February 3, 2015

**RE: Revised Grading Plan (C-18D012)
American Toyota
Albuquerque, New Mexico**

AMERICAN TOYOTA EXPANSION
Albuquerque, New Mexico

AMERICAN TOYOTA  
ALBUQUERQUE, NM

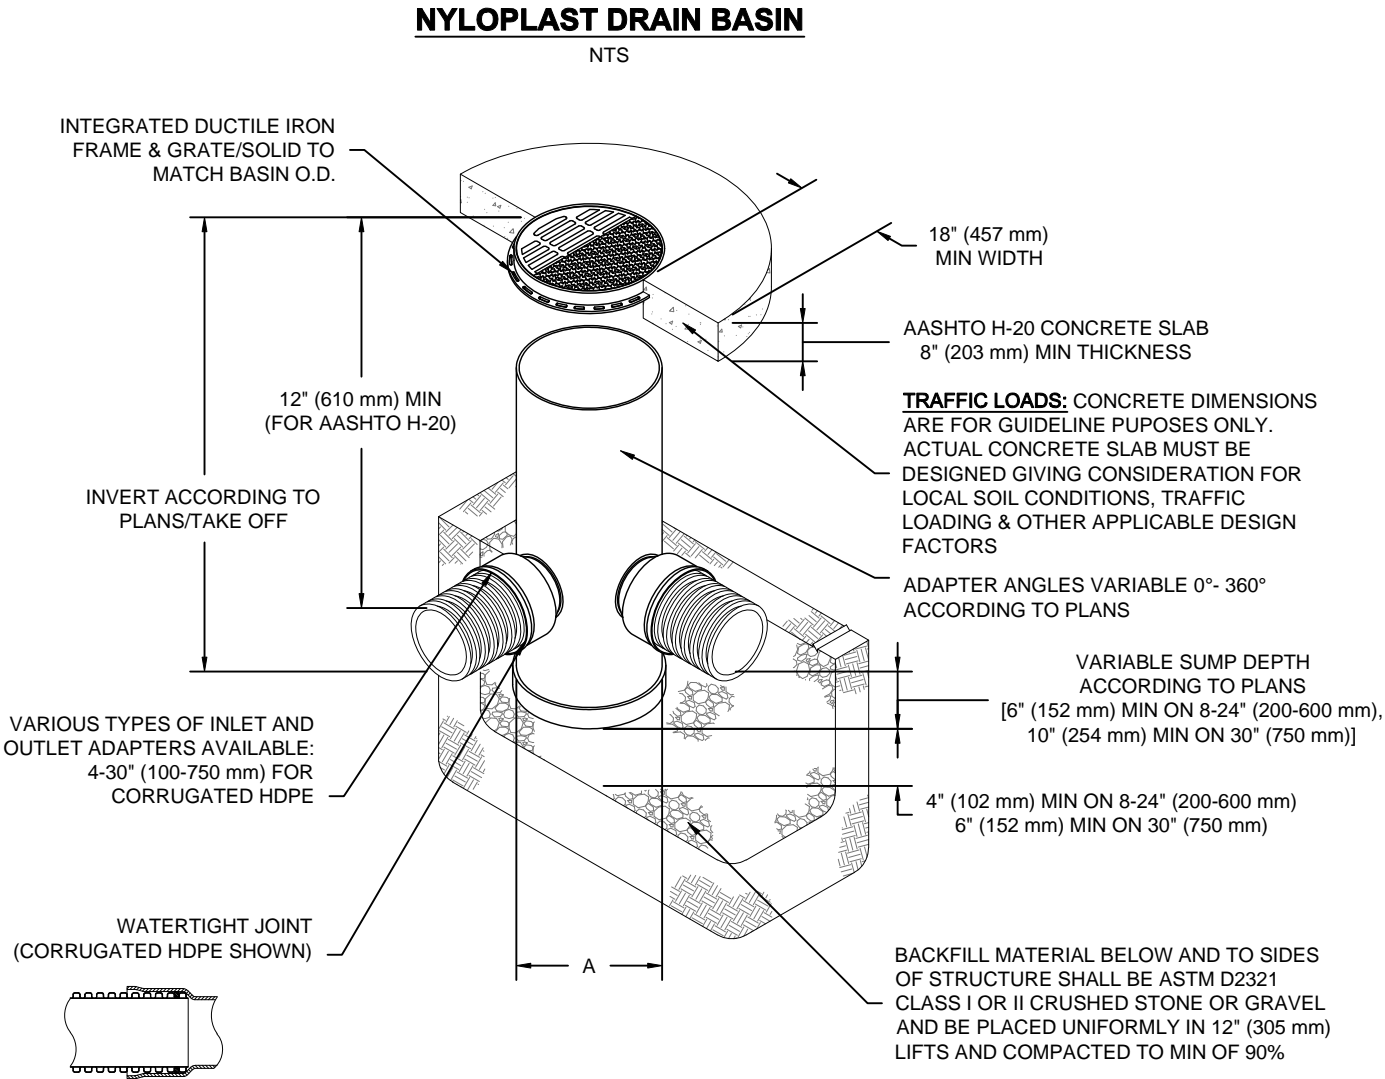
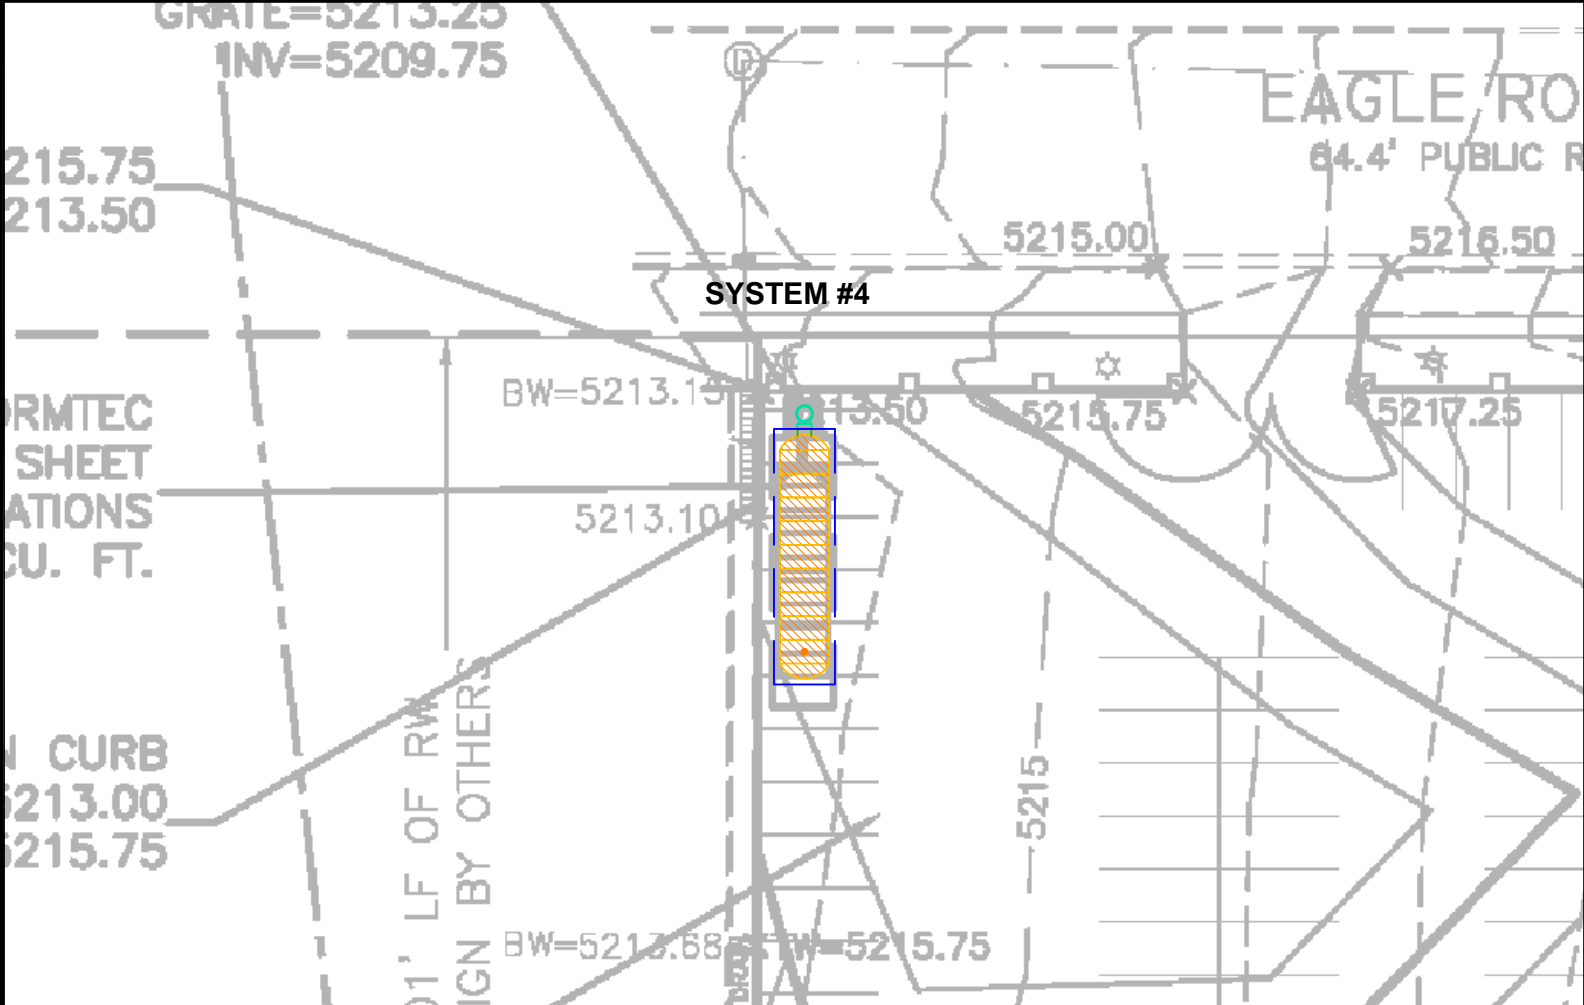
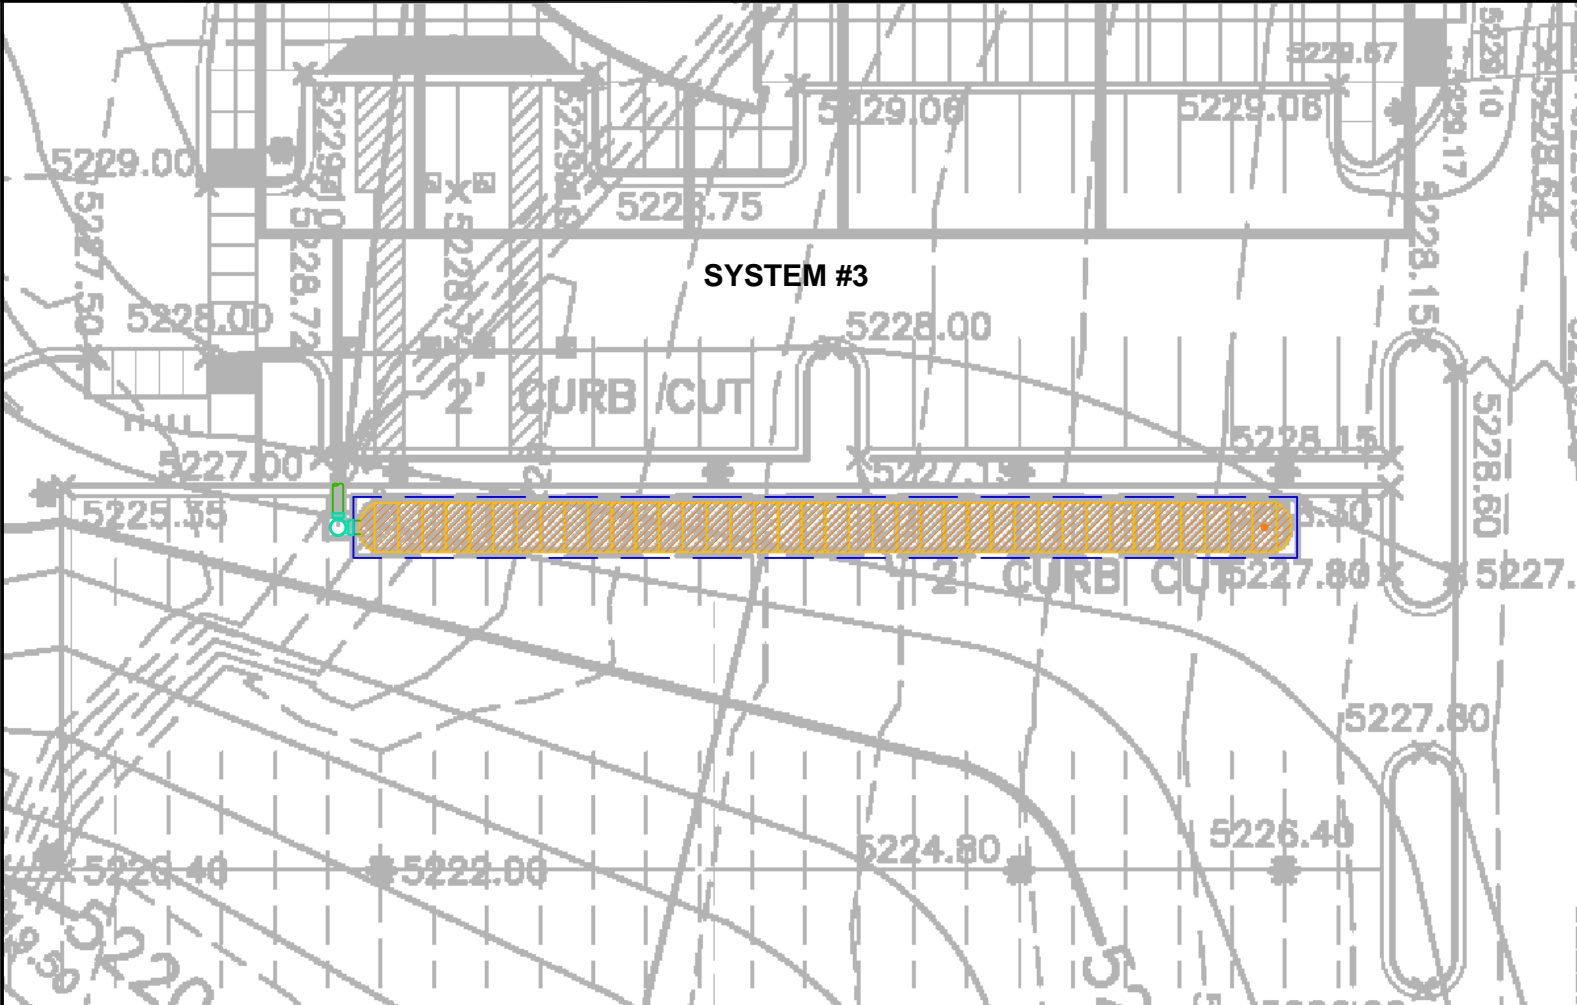
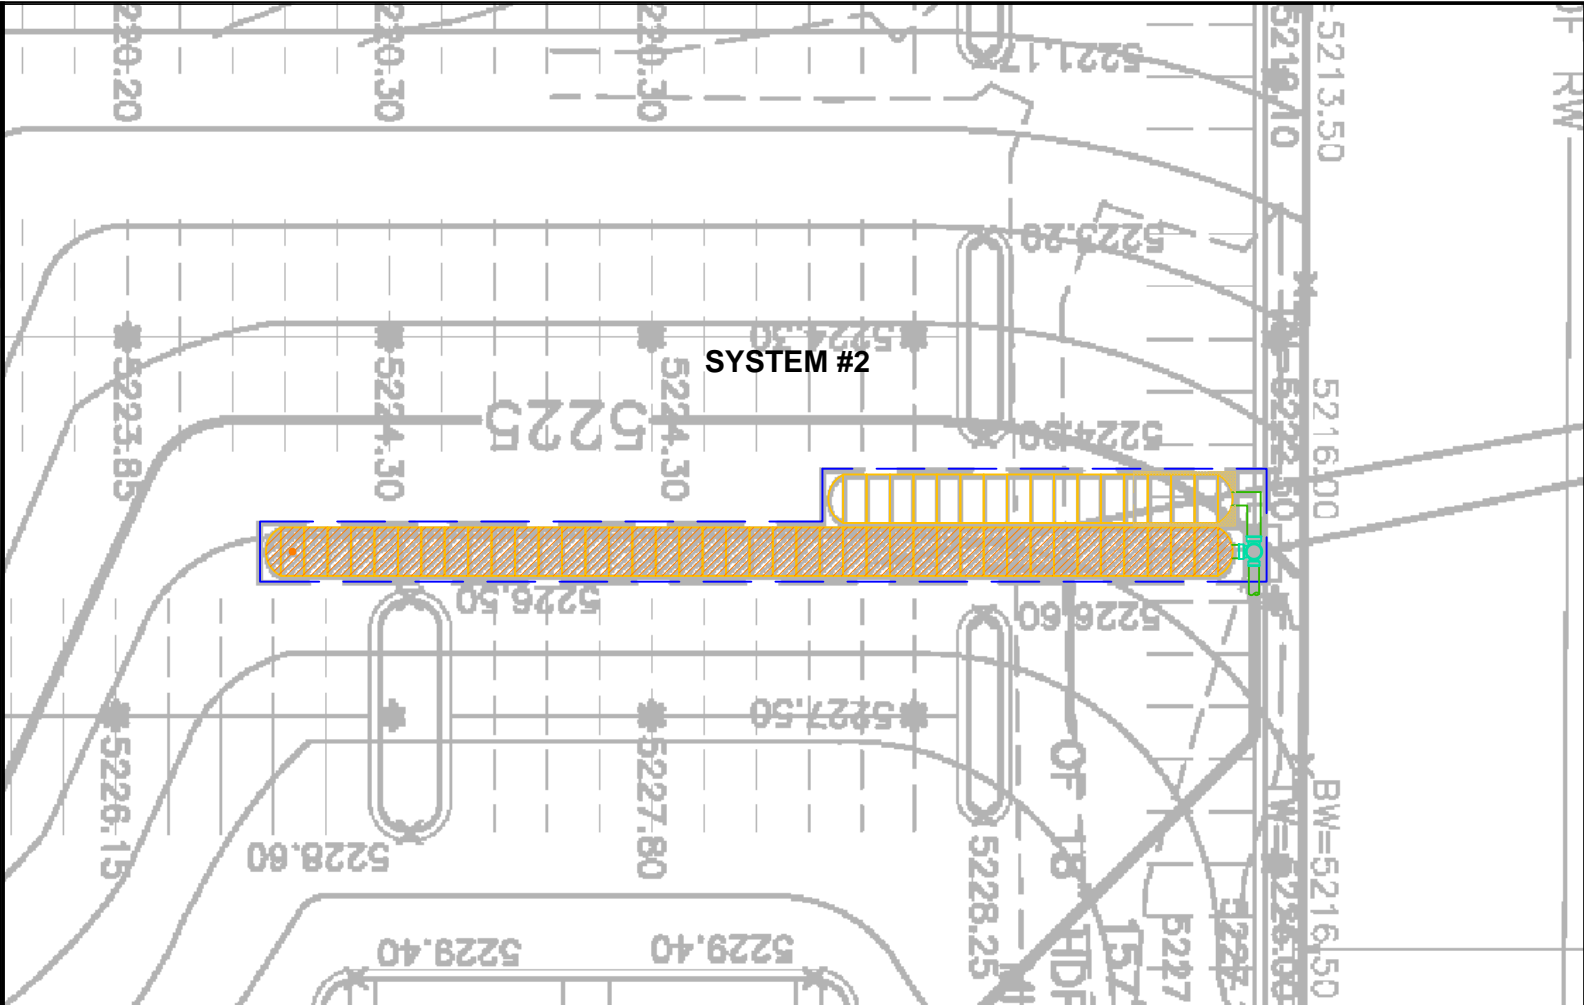
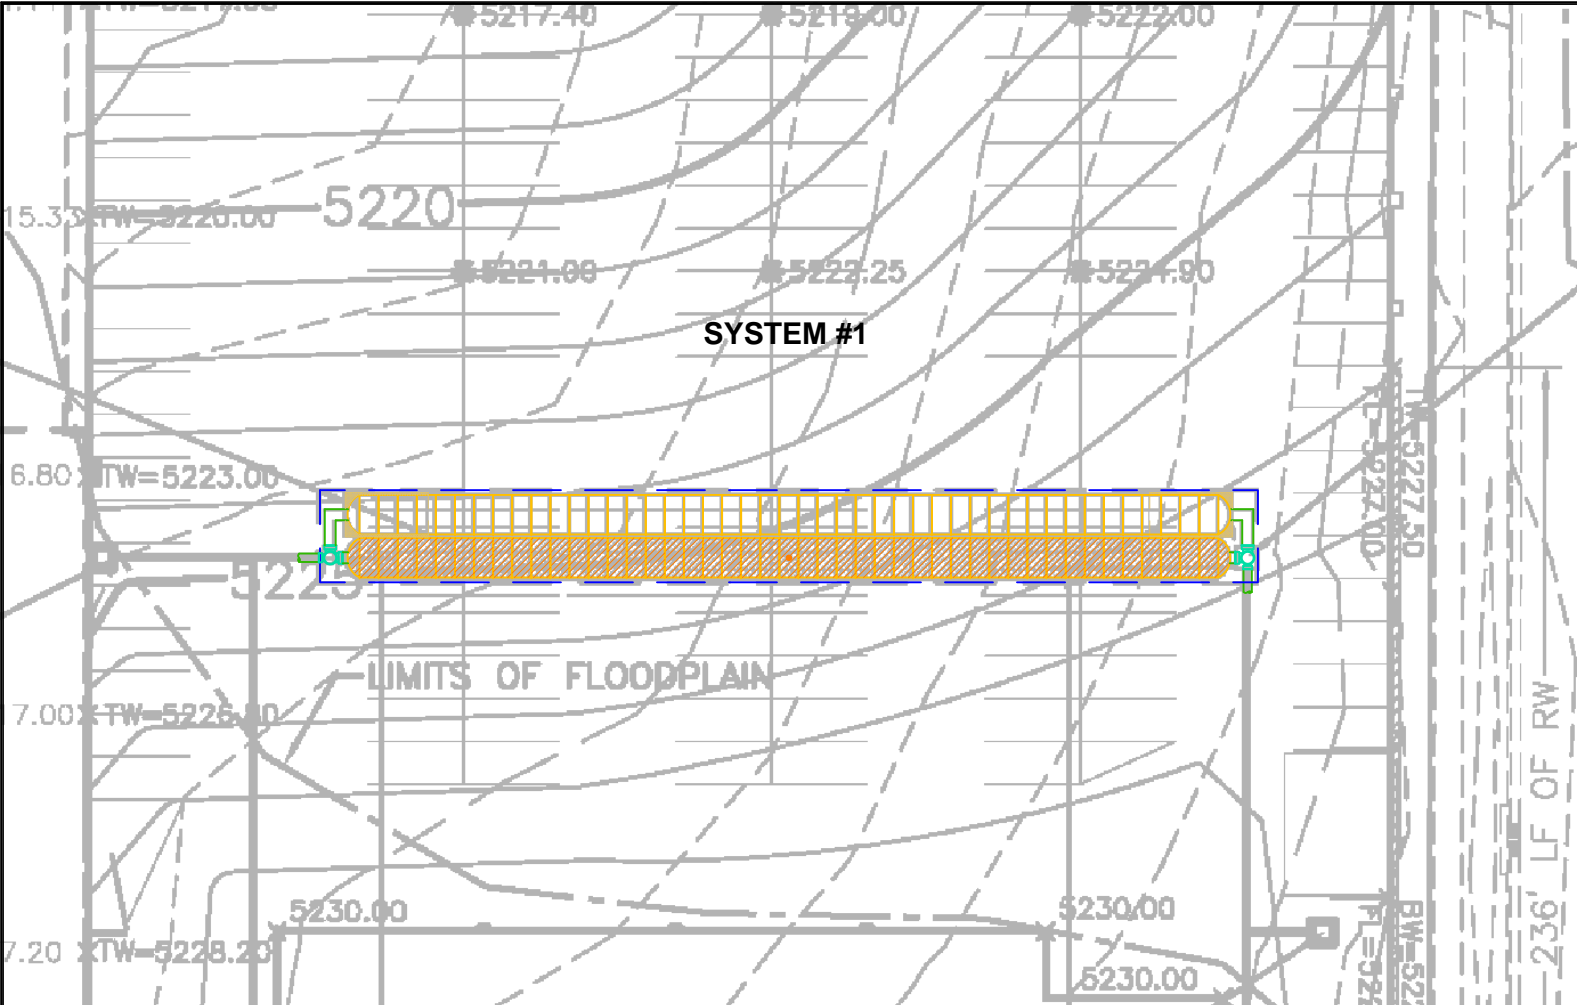
7. Include calculation for the design of the stormtech systems

8. Provide a detail sheet for storm tech system specific to this site

9. How will the storm tech manifold system be done. Provide detail of how to be built

We have included details and calculations for each system,

We have included the details from the manufacturer.

We have included details of system and layout.
